Response to Submissions Report

State Significant Development – SSD 18_9095

Armidale High School Redevelopment

Butler Street, Armidale

From the junction of Miller and Kentucky Streets at the far western boundary of the site, glimpses through the trees provide views across the school's agricultural lands. The Arboretum extends up hill on the south and the school site falls steadily away to the north.

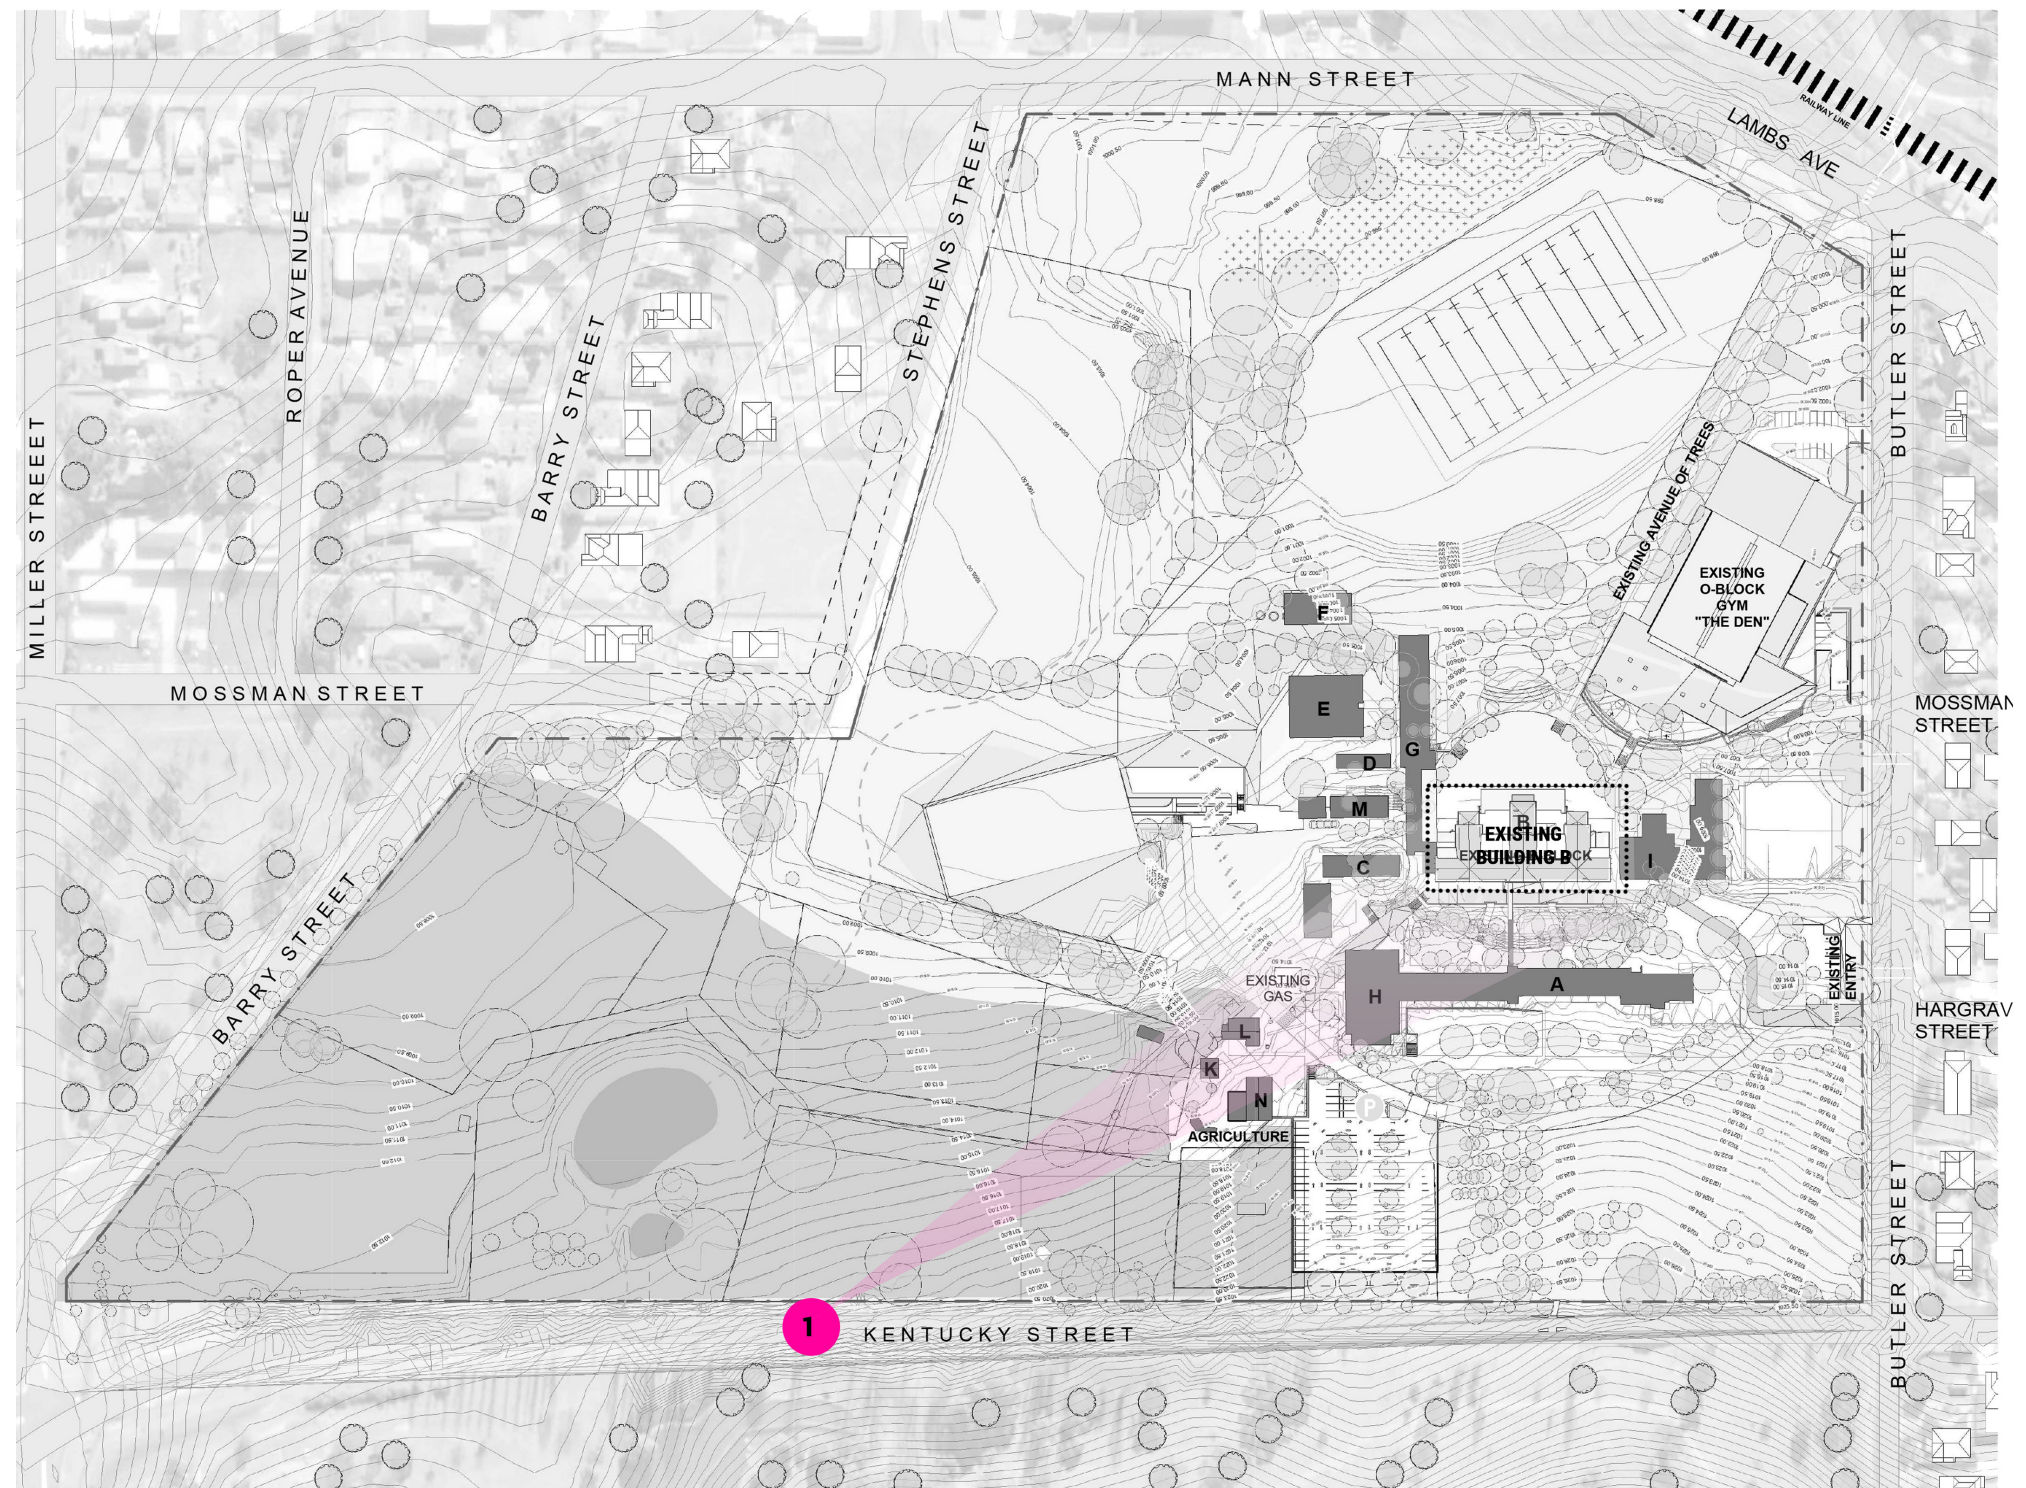
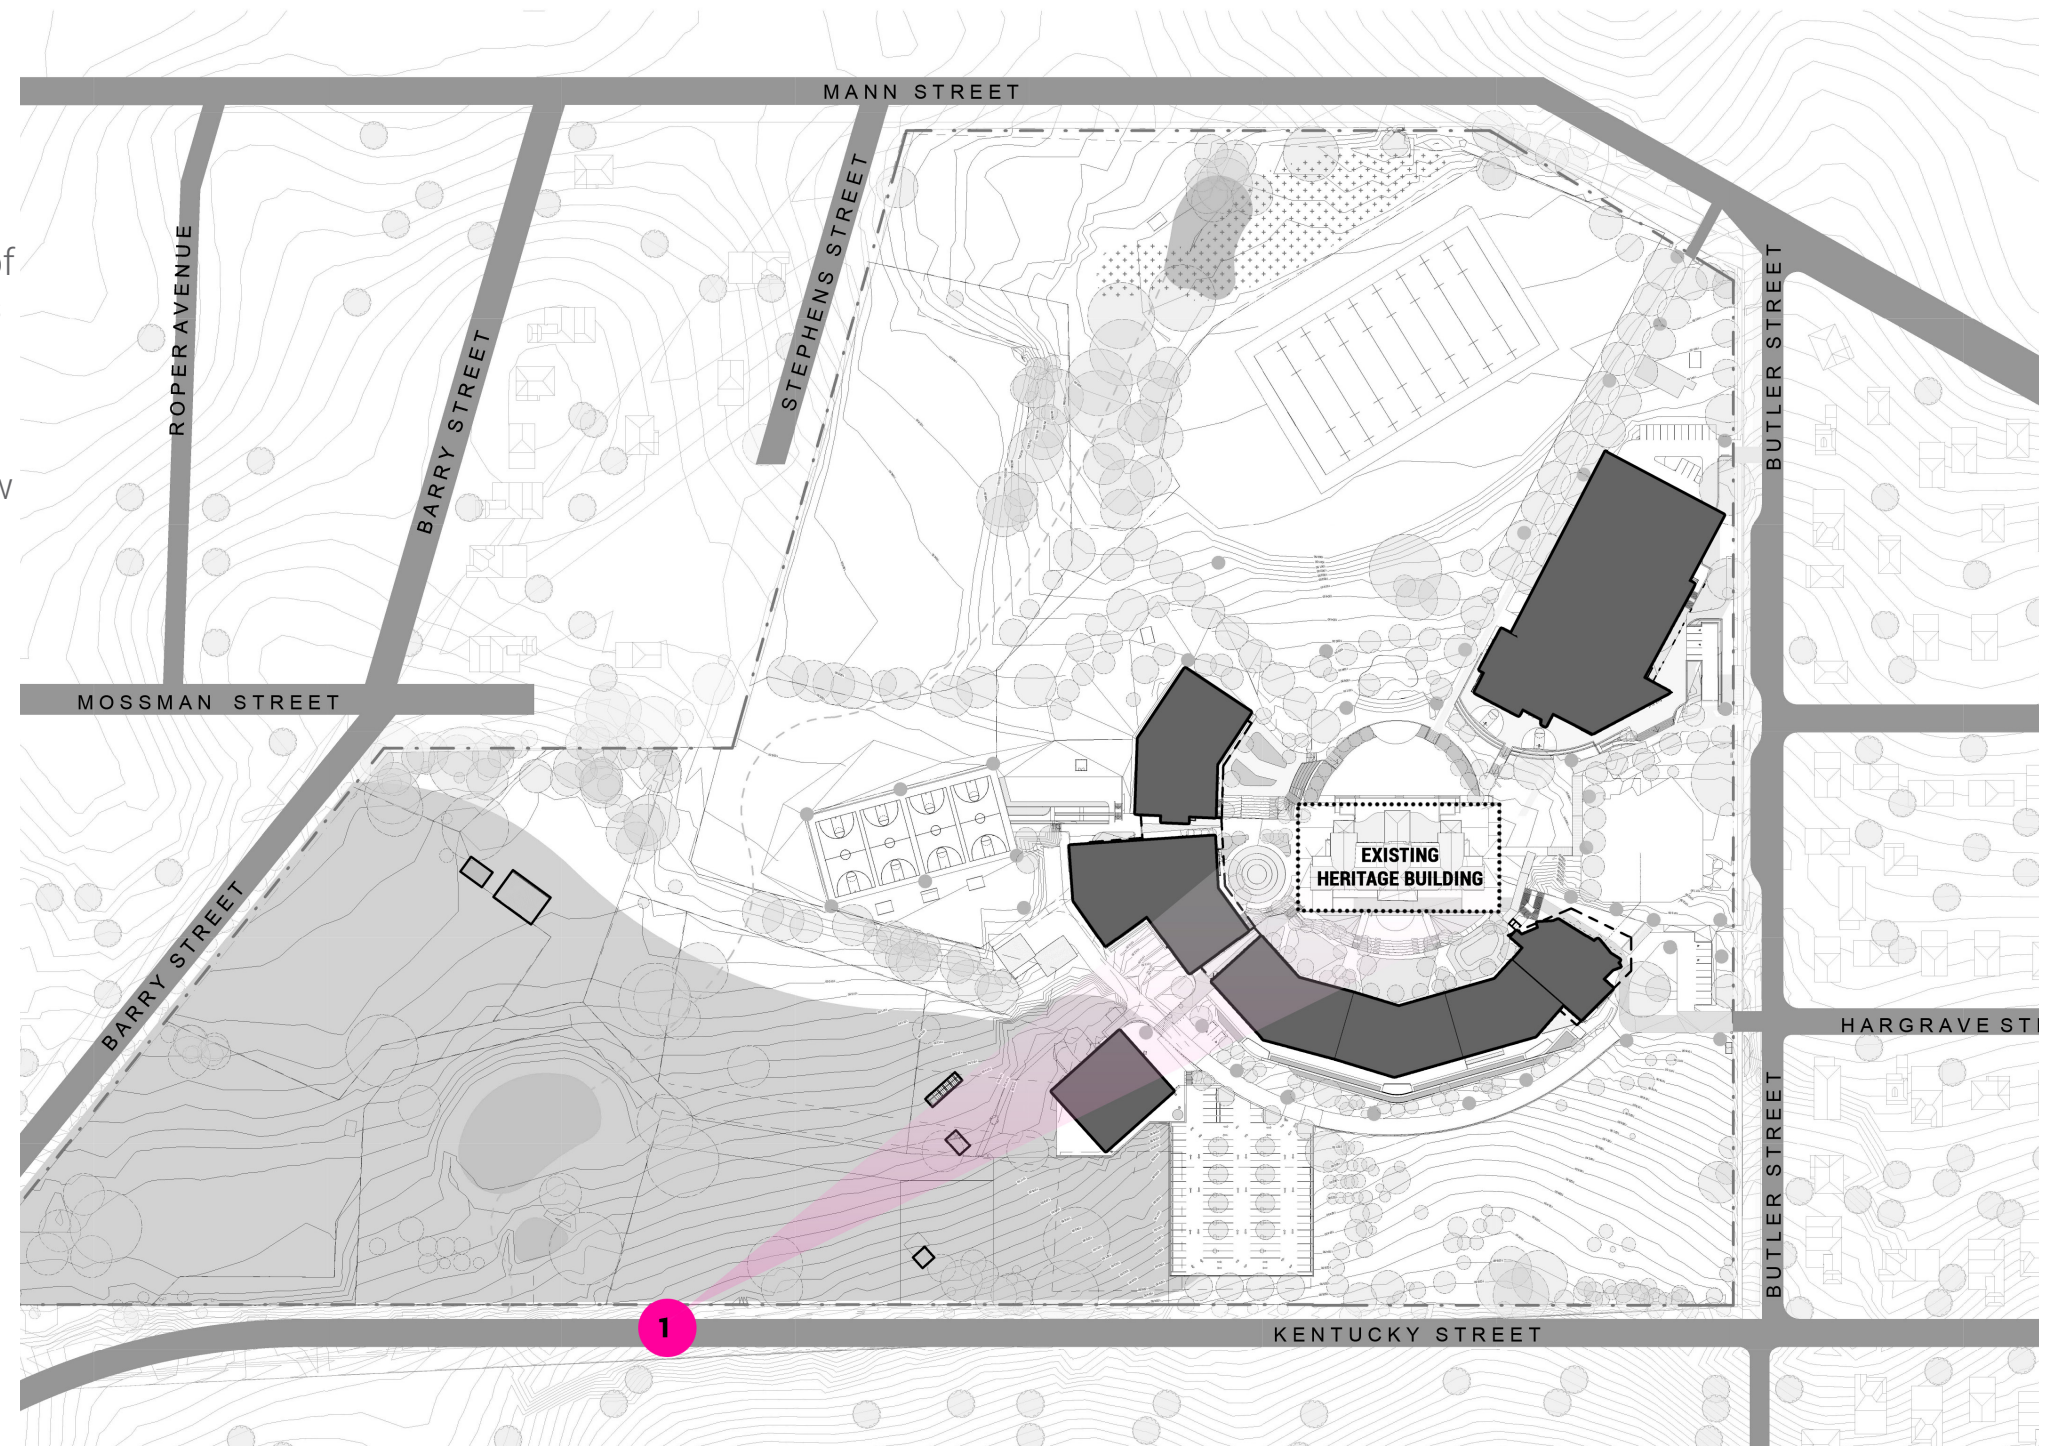
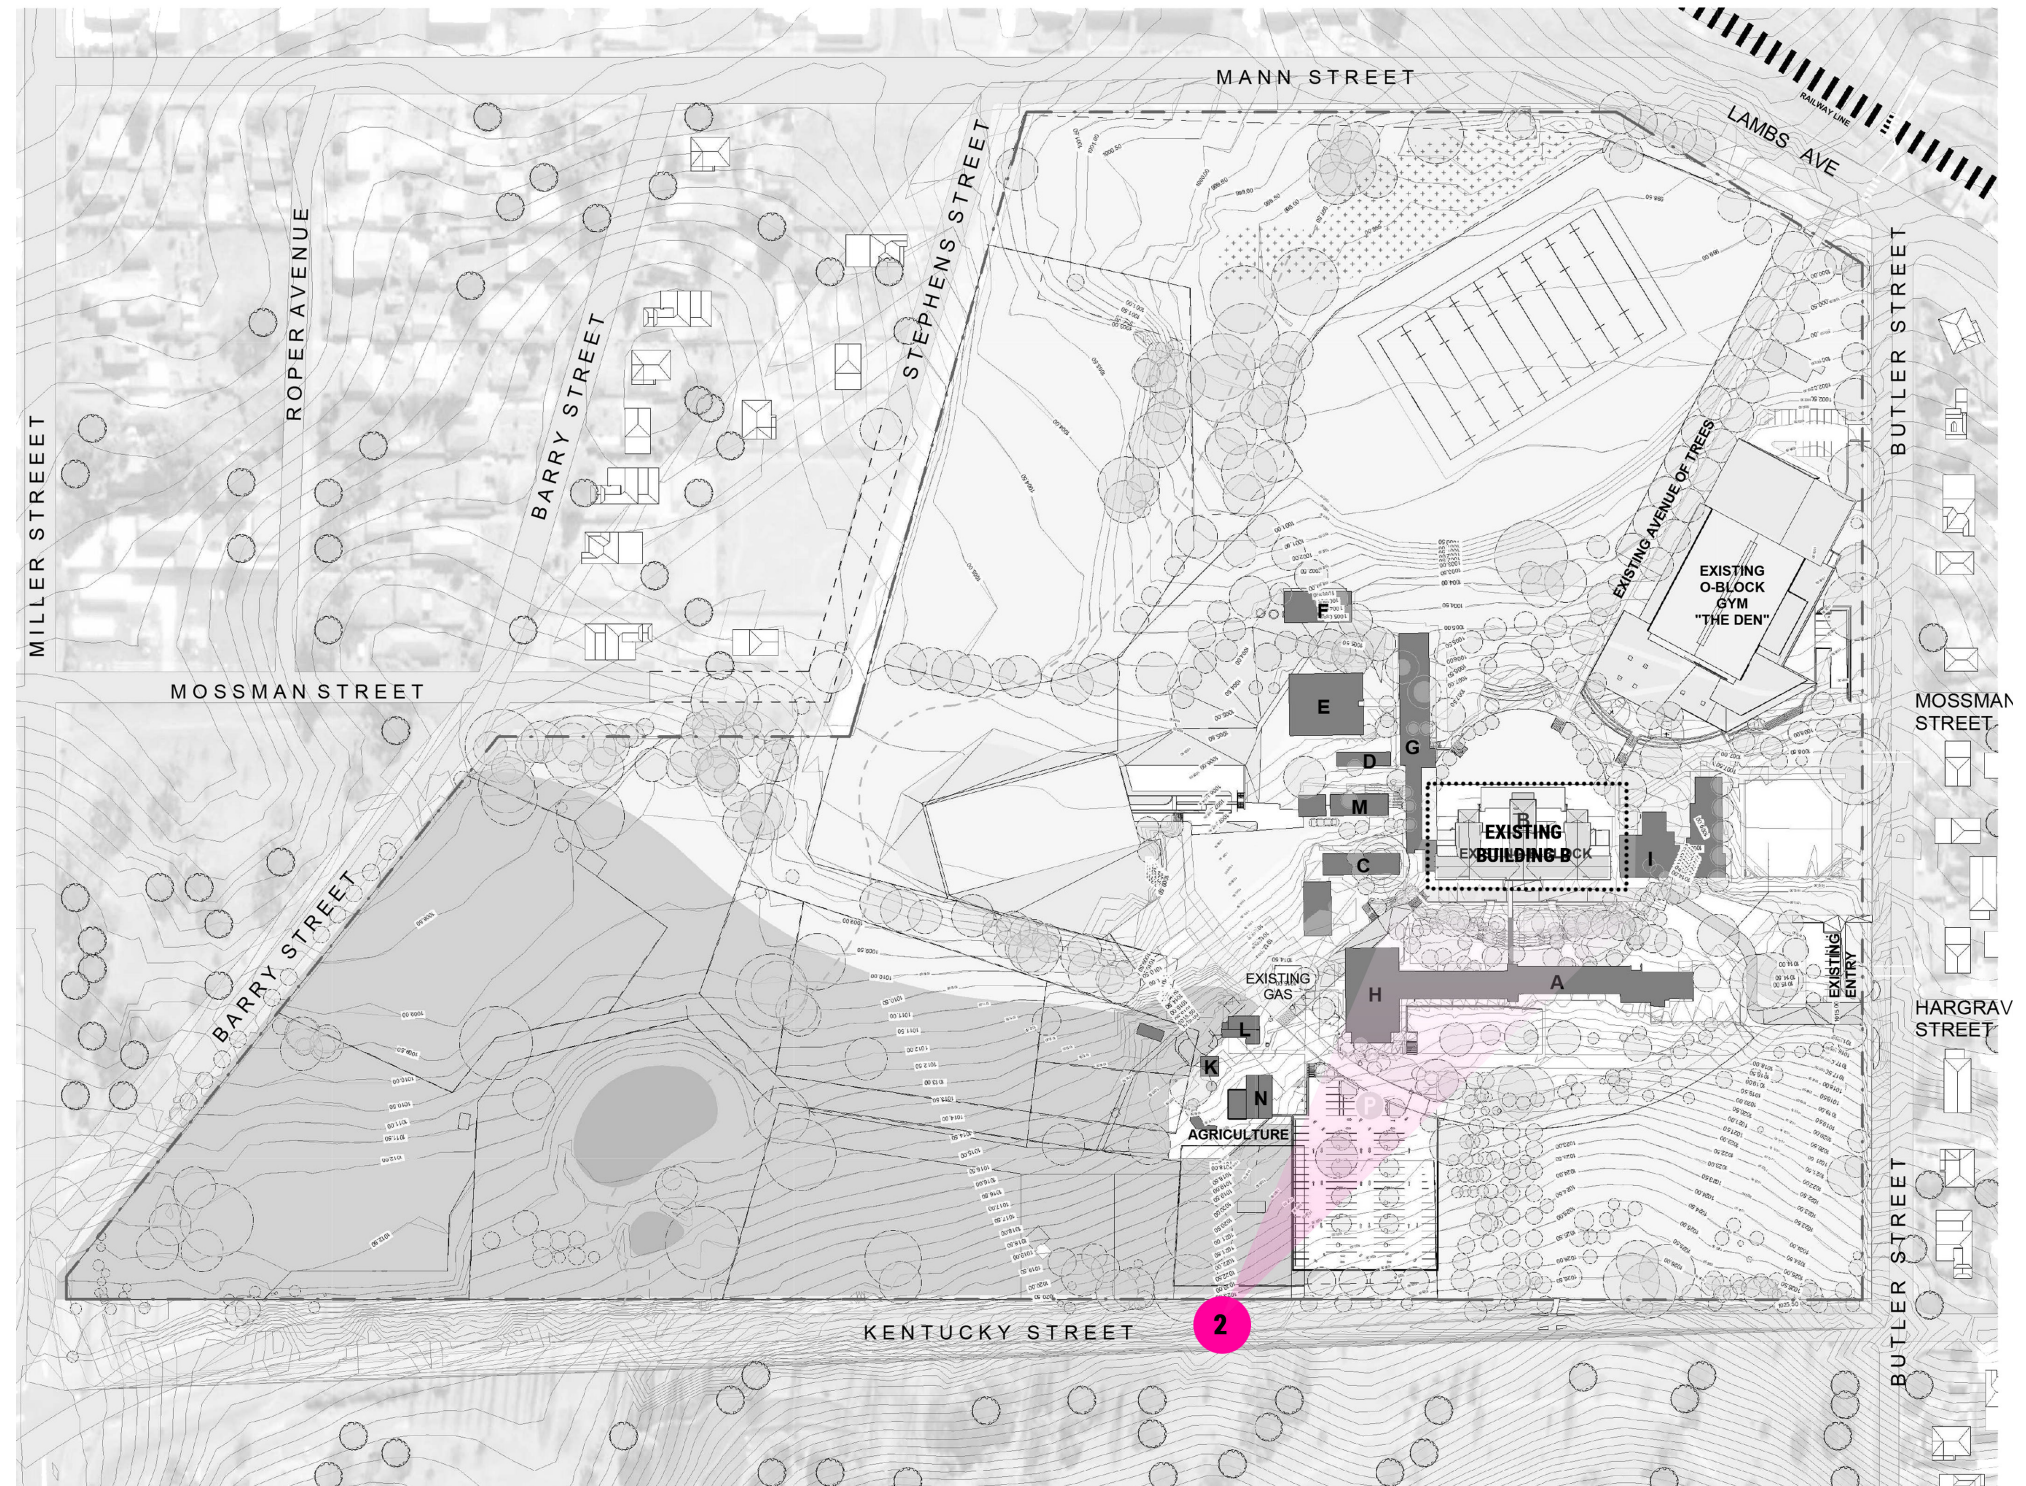
7. While it is acknowledged the Council did not raise concerns with regard to the proposed development, the Heritage Council has raised concern with regard to the impact of the proposal on significant views to the locally listed heritage item. Additional information is required addressing the impact of the proposal on the significant views.	The View Analysis provided as part of the original DA submission (refer Appendix 16 of the EIS) has been updated to provide additional information, including: - Comparison between existing and proposed views at significant viewpoints around the site; - Demonstration as to how these views would be maintained with the construction of the proposed buildings; and - Consideration of the impact the proposed buildings would have on significant views, including potential improvement to views or prominence of visual settings within the site. Further, it is noted that the design change to accommodate air conditioning (resulting in an increase in building height by 300mm) has been incorporated into the expanded View Analysis.	View Analysis Appendix 2
